Recommendation Report for Planning Permission for Works or Extension to a Dwelling

REF NO: M/92/25/HH

LOCATION: 100 Ancton Way
Elmer
Middleton-on-sea
PO22 6JR

PROPOSAL: Proposed front porch.

Proposed Front Porch
Plans and Elevations
Planning
Date
November 2025
Scale
1:50

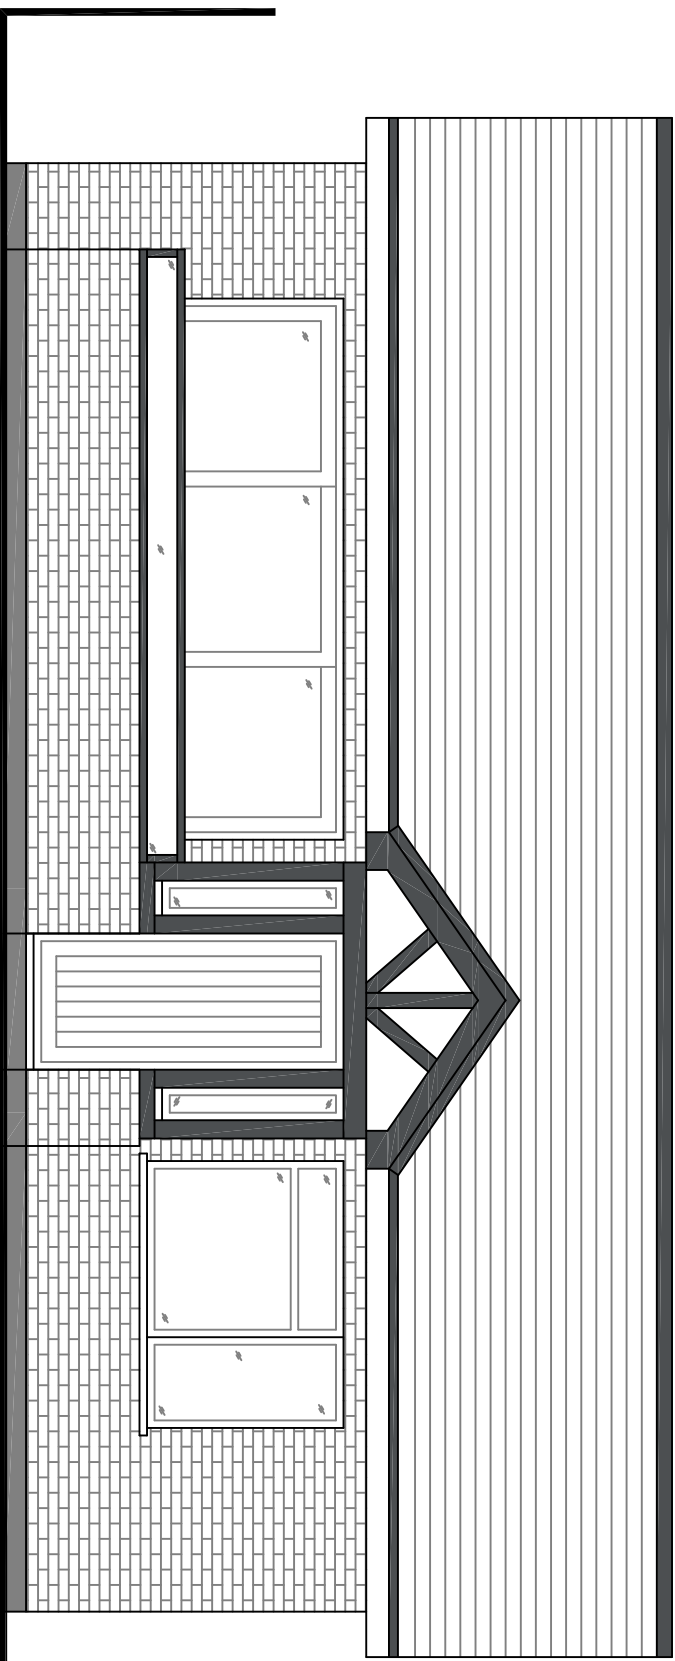
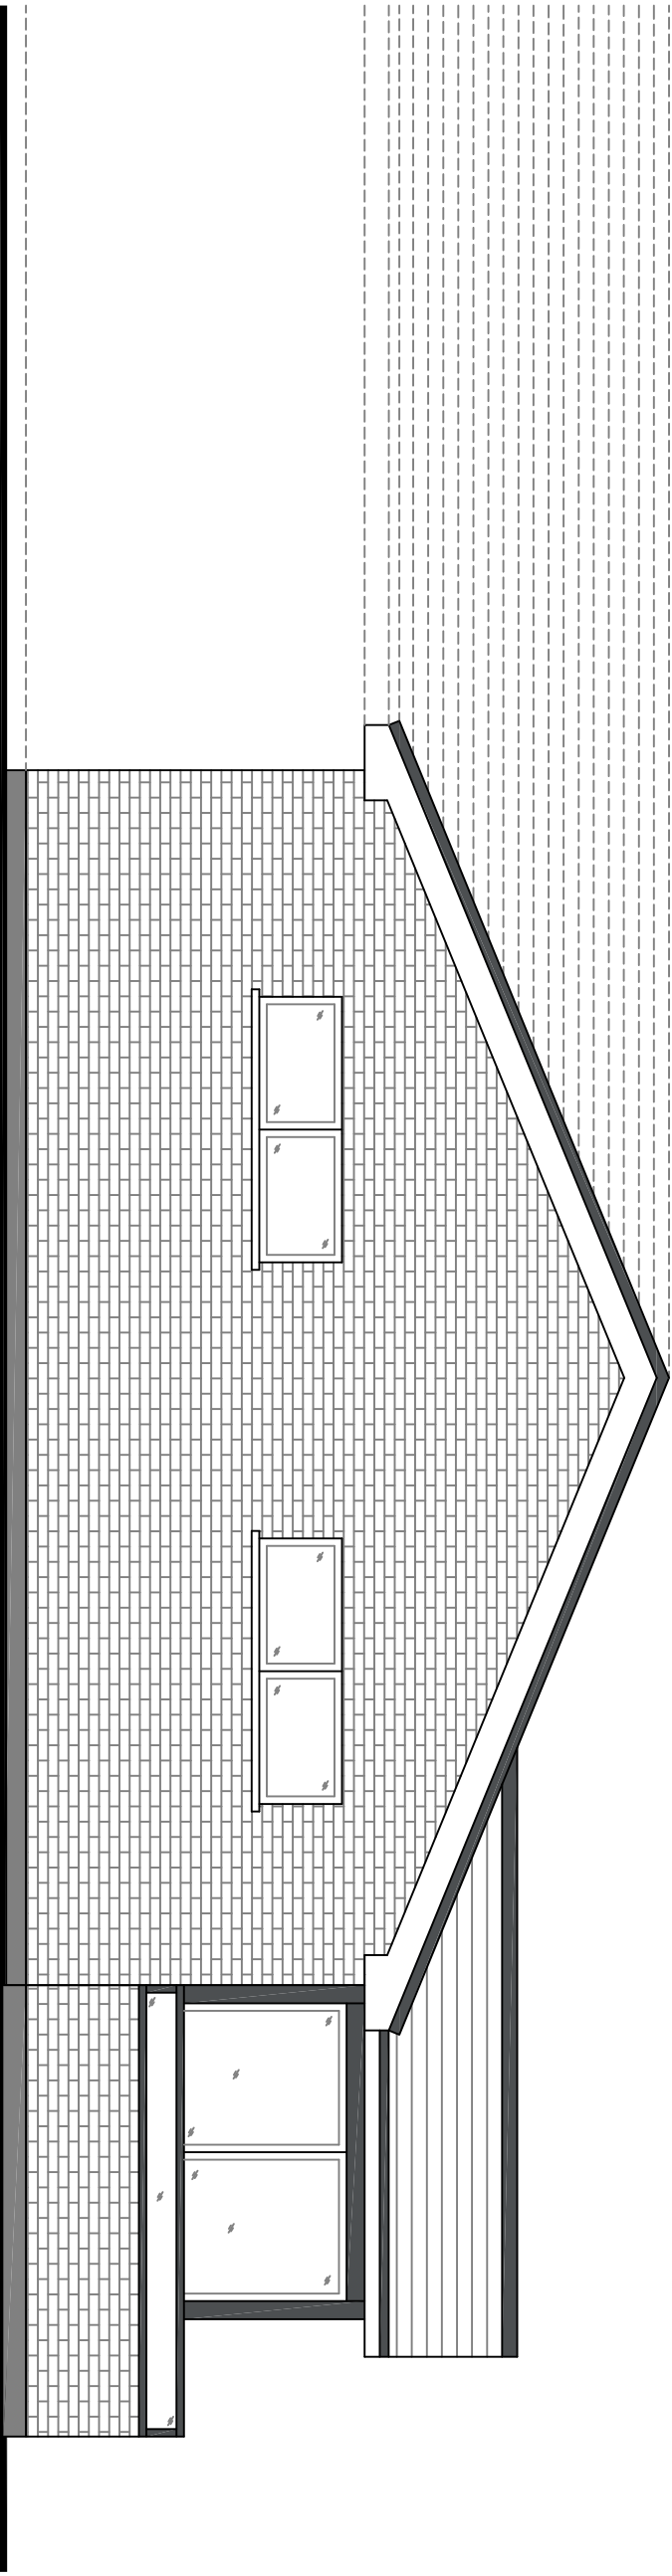
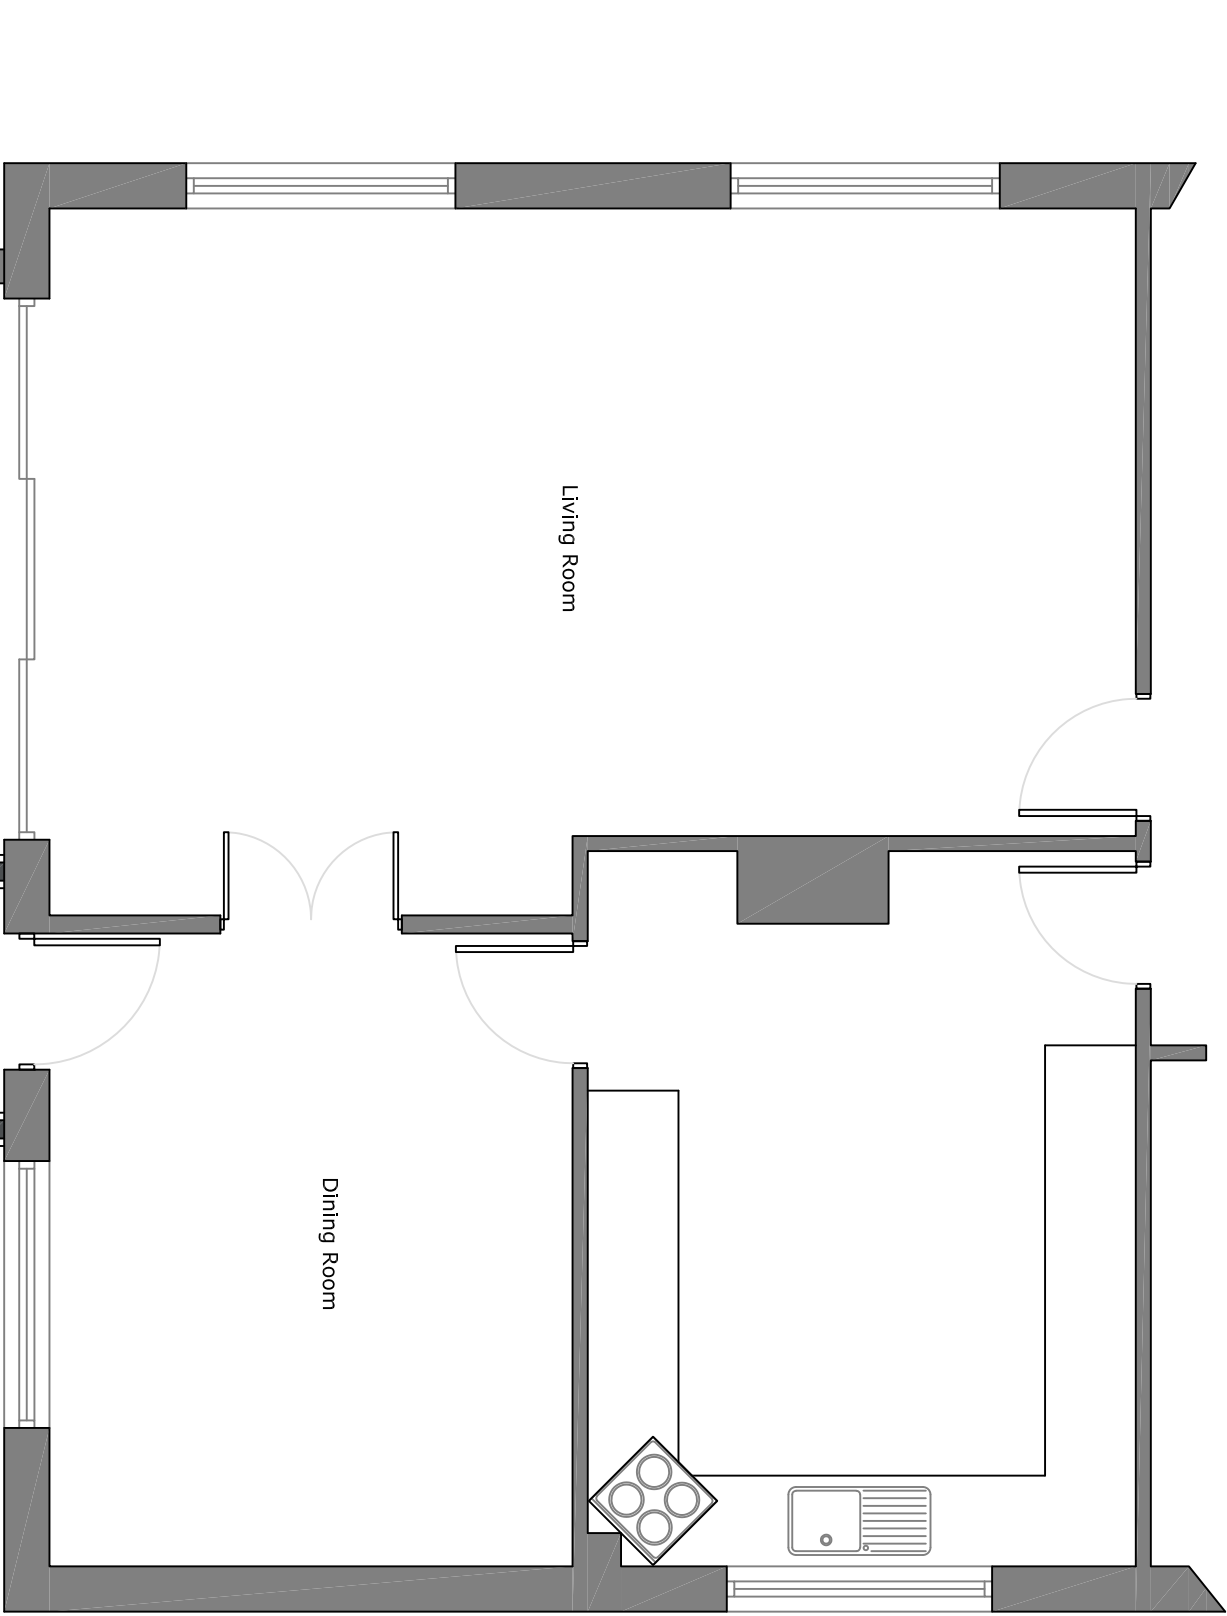
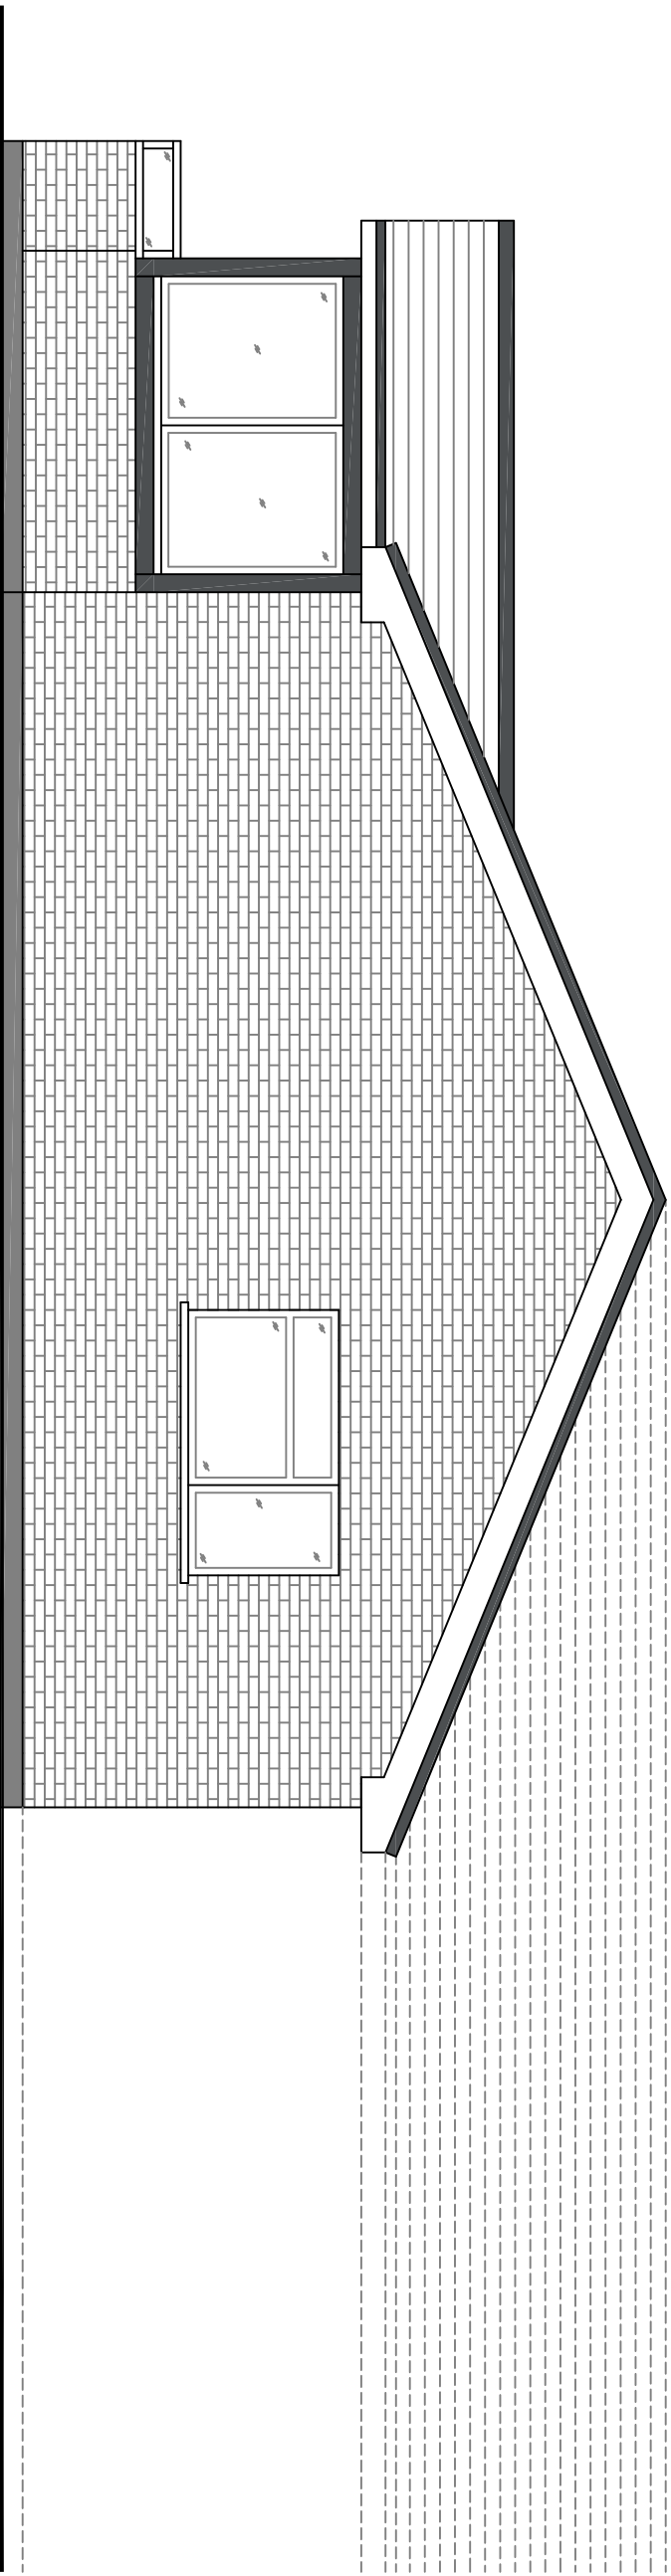
The proposed porch would measure approximately 1.9m in width and 2.2m in depth. It would be constructed in brick to match the host dwelling and include new entrance door. The porch would have a pitched tiled roof to match the existing with a maximum height of 3.4m and an eaves height of approximately 2.5m. The existing raised brick wall with planting to the front of the property would be removed and replaced with a new wall measuring approximately 1.2m in height. This wall would align with the front elevation of the proposed porch and extend towards the dwelling to create an enclosed area, providing access from the existing patio door.

The proposed fenestration would comprise a new entrance door flanked by two small horizontal windows. Additional windows would be installed on both side elevations (east and west).

The porch would be visible within the street scene and would exceed the 1.5m guidance for the depth of front extensions outlined within the Arun Design Guide (ADG), however, the surrounding area is characterised by a varied form, scale and appearance, with a number of nearby dwellings incorporating similar front projections. The proposal would be set back from the highway and, due to its modest scale and design, would not appear unduly prominent or visually intrusive. The development would be finished in materials that match, or closely resemble, those of the host dwelling and would not adversely affect the character or appearance of the surrounding area, in accordance with policy D DM1 of the Arun Local Plan (ALP).

The porch would be set in approximately 6.2m from the neighbouring boundary to the east and approximately 5.3m from the neighbouring boundary to the west, thereby maintaining suitable separation distances. The southern boundary of the site fronts the highway, and as such, the proposed porch would not have any residential impact to the south. The proposed porch would not result in overbearing or overshadowing impacts to any neighbouring dwellings.

The proposed windows within the side elevations would be positioned at ground floor level. Given their orientation and the separation distances to the neighbouring dwellings, the development would not result in any loss of privacy or overlooking.

The proposed alterations to the low wall to enclose the existing patio area to the front of the dwelling would not result in any harm to neighbouring properties.
